M25 junction 10/A3 Wisley interchange

TR010030

10.1 Report on Proposed Scheme Changes

Version	Date	Status of Version
Rev 1	18 February 2020	Deadline 4a
Rev 0	11 February 2020	Request for Change

Figure 3.1 – Widened “Green Element” of Cockcrow Bridge

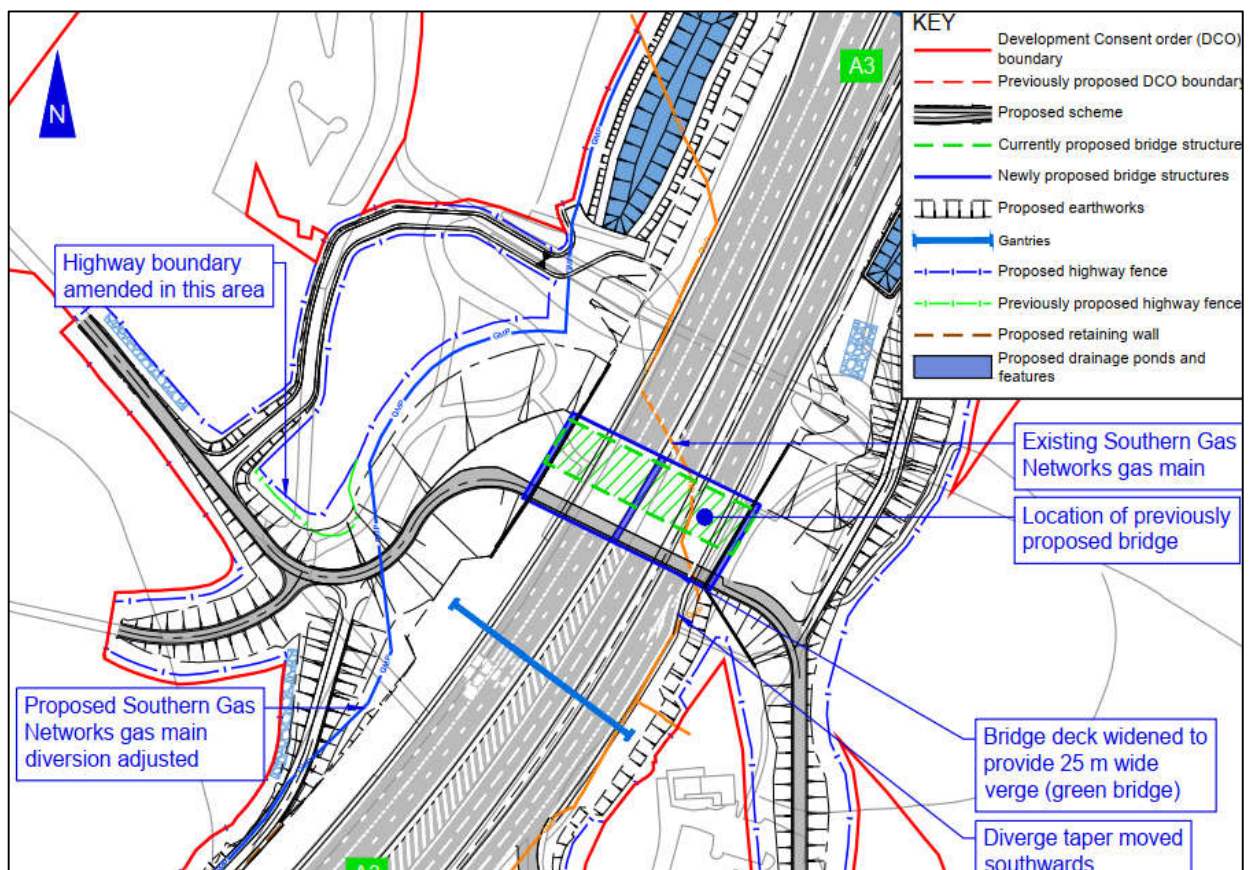
3.1.1 Following stakeholder engagement, Highways England proposes to increase the width of the green verge at the new Cockcrow Bridge from the 10 metres provided for as part of Work No. 35(b) in Schedule 1 of the dDCO to a 25 metre width. This change is supported by relevant stakeholders including Surrey County Council and Surrey Wildlife Trust.

3.2.2 It will also increase the footprint of the green bridge within the existing Scheme boundary on account of the wider approach ramps which will be necessary given the expanded width of the bridge.

3.2.3 The widened approach embankments will require the placement of an additional 5000 m³ of material.

Figure 4.1 – Proposed Toad Underpasses on Old Lane

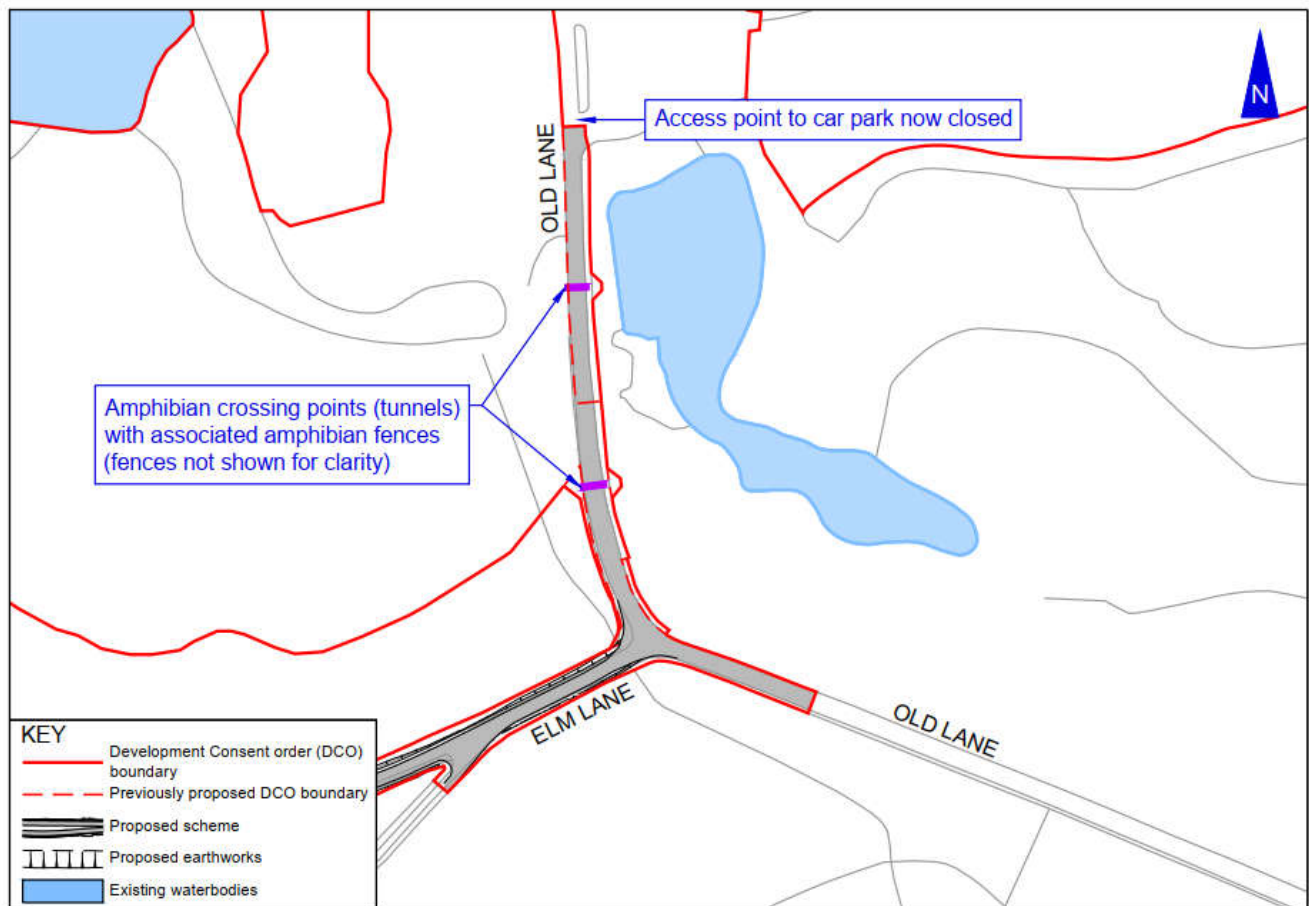
4.1.2 Accordingly, Highways England proposes to develop mitigation measures to include two toad underpasses at a section of Old Lane together with reptilian fencing to direct the toads to the underpass crossing points. Additional signage will also be provided along Elm Lane.

- 4.1.3 The proximity and relative level of the water body to the east of Elm Lane means that the form of the underpass is likely to be shallow and most likely to be contained within the structure of the existing carriageway.

4.2.11 The proposals include two 150 m lengths of 300 mm high wildlife barrier either side of Old Lane which would have negligible effect on the landscape or visual impact of the scheme.

**Figure 5.1 – Revised Layout of A245 Eastbound Carriageway**

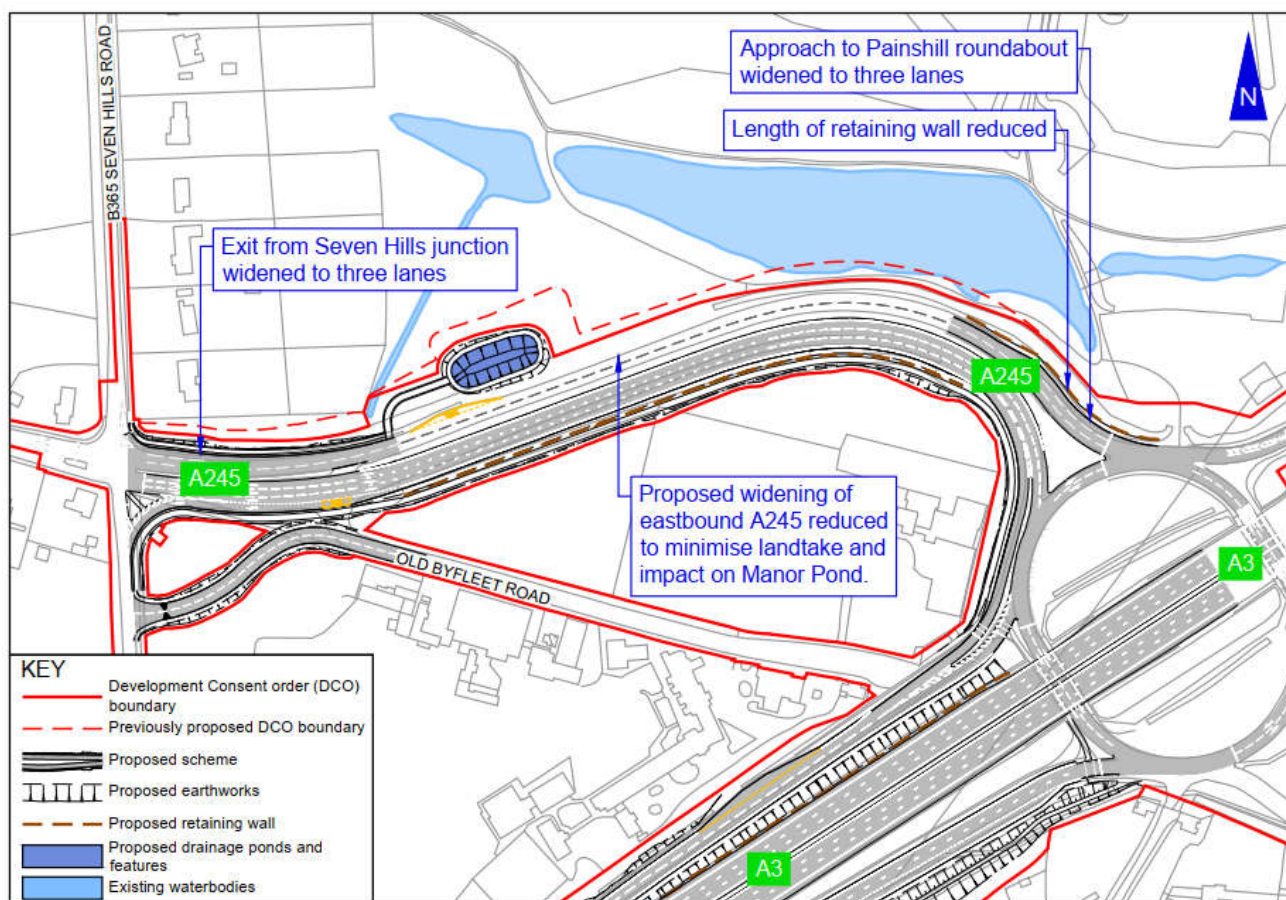
- 5.1.2 Highways England has undertaken further traffic modelling of the traffic flows at this junction in consequence of the incorporation of a banned right-turn and in the light of that modelling it is no longer necessary to widen the entirety of this section of the A245 to three lanes as it passes Manor Pond and approaches the A245/A3 Painshill interchange.

- 5.1.4 Accordingly, it is no longer necessary to construct Work No. 47(c), comprising the construction of a retaining wall at Manor Pond, which it is proposed will be removed from the dDCO in consequence of this change.
